From: Paul Cann
Sent: 15 May 2017 11:58
To: Planning.Responses
Subject: RE: Planning Consultation on AL/38/17/DOC

APPLICATION NO: **AL/38/17/DOC**

Site Address: The Thatched House Littleheath Road Aldingbourne BN18 0SR

Description of Works: Application for approval of matters reserved by condition imposed under AL/127/16/HH relating to conditions 3 for samples of materials & finishes & 5 for surface water drainage.

| Drawing<br>Number                                                                                                                        | 1727/D1.1 | Revision    | -  |

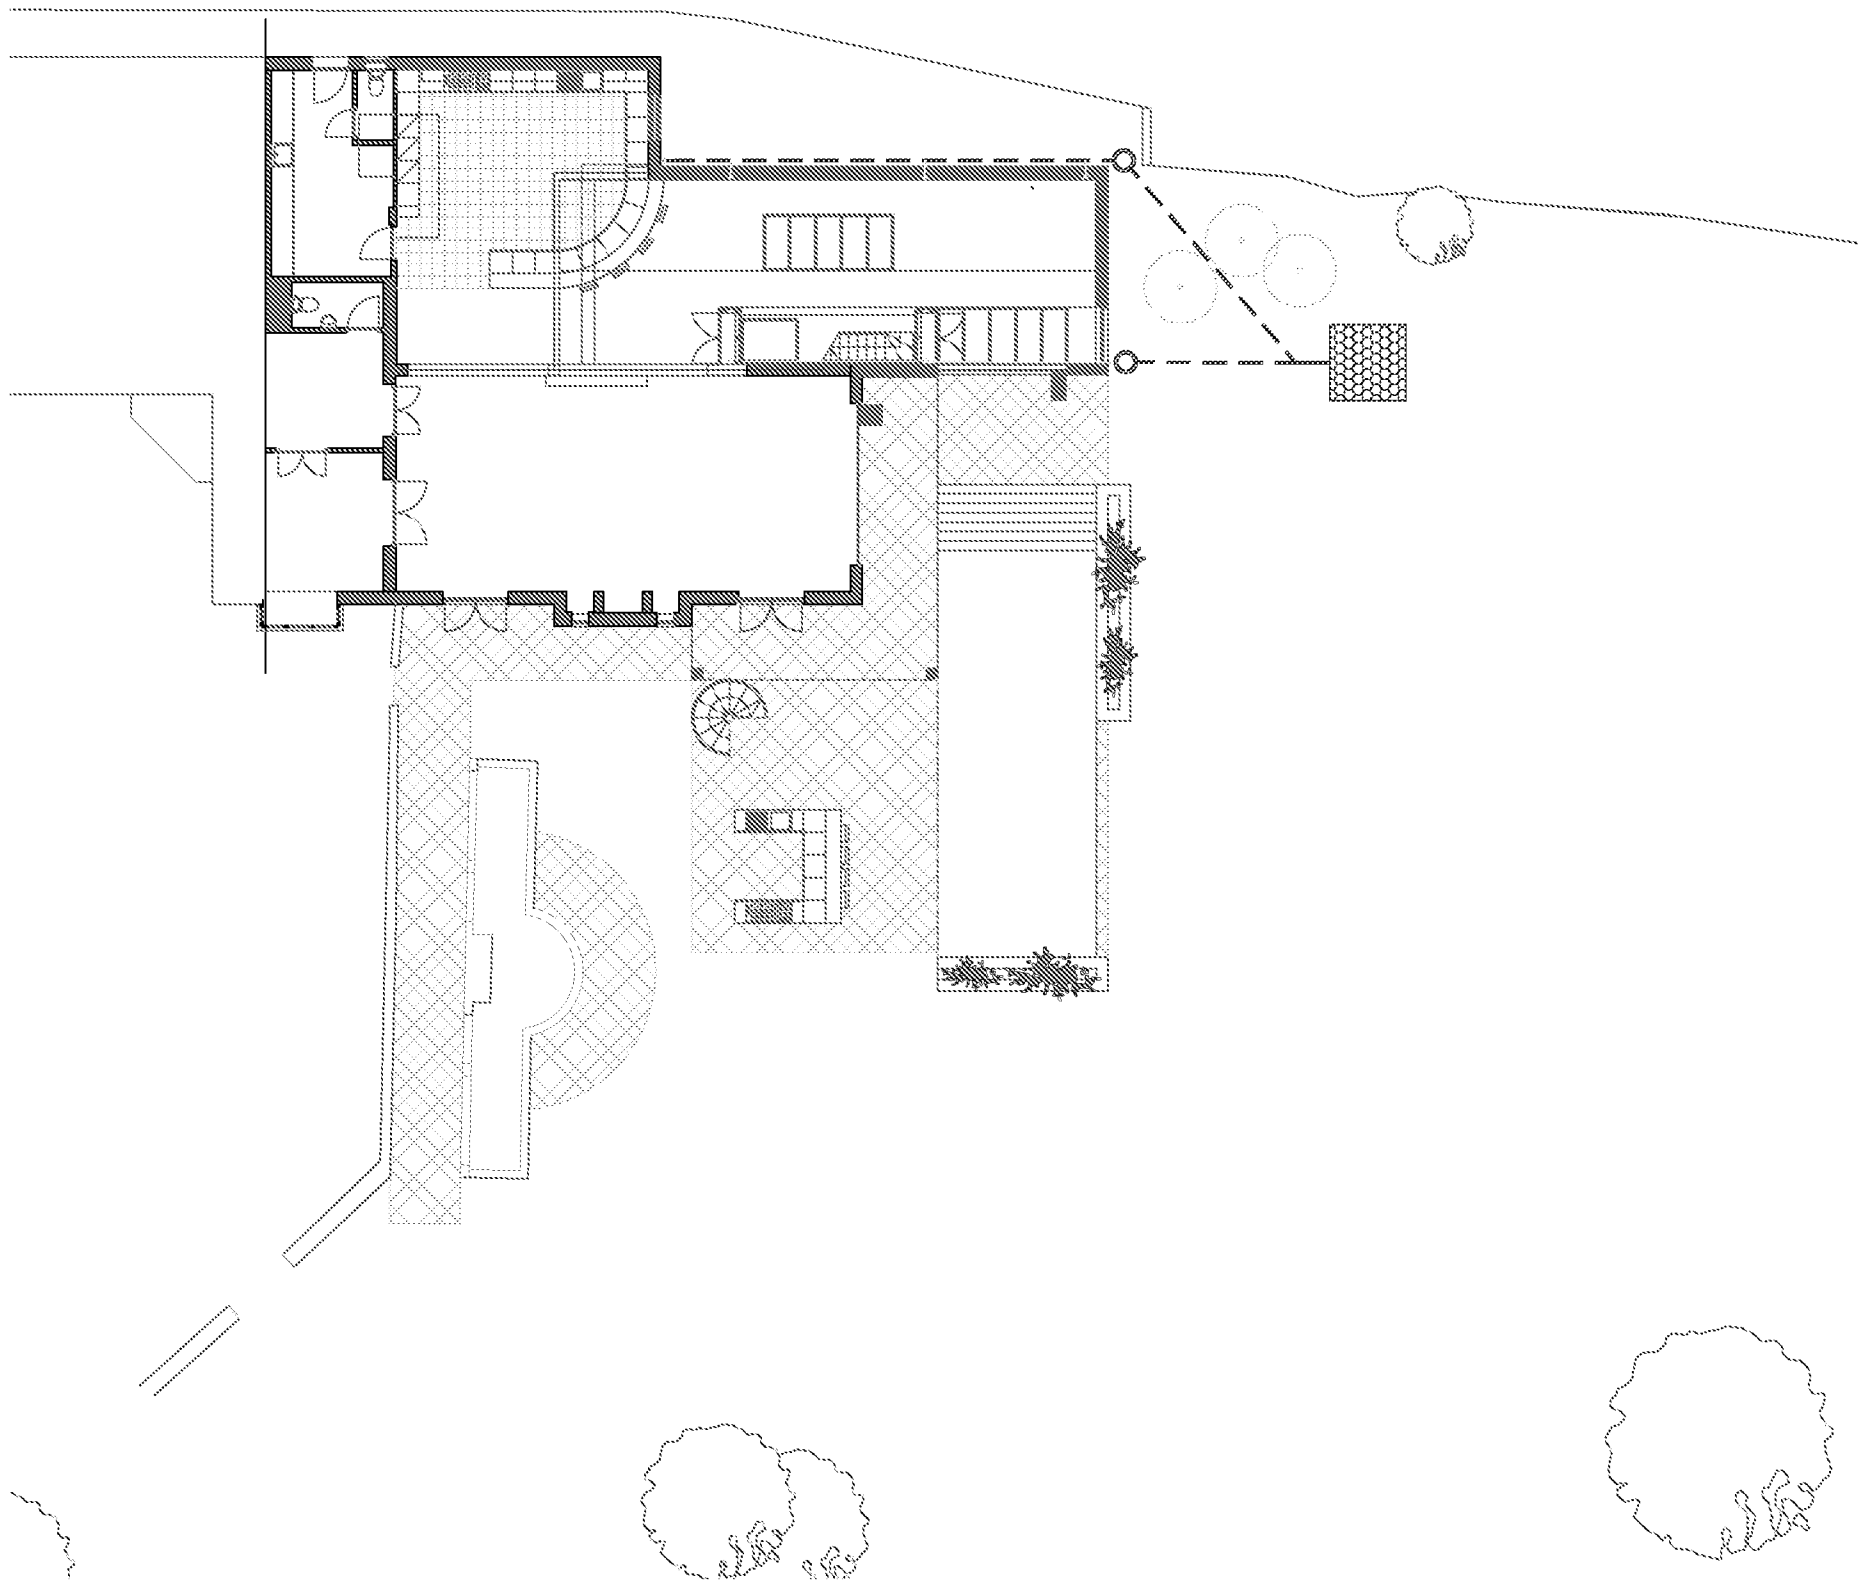
To support the proposal, the applicant needs to provide a construction detail (cross section) for the crated soakaway, to include all relevant levels of incoming pipes, etc. Silt trap manhole detail is also to be provided.
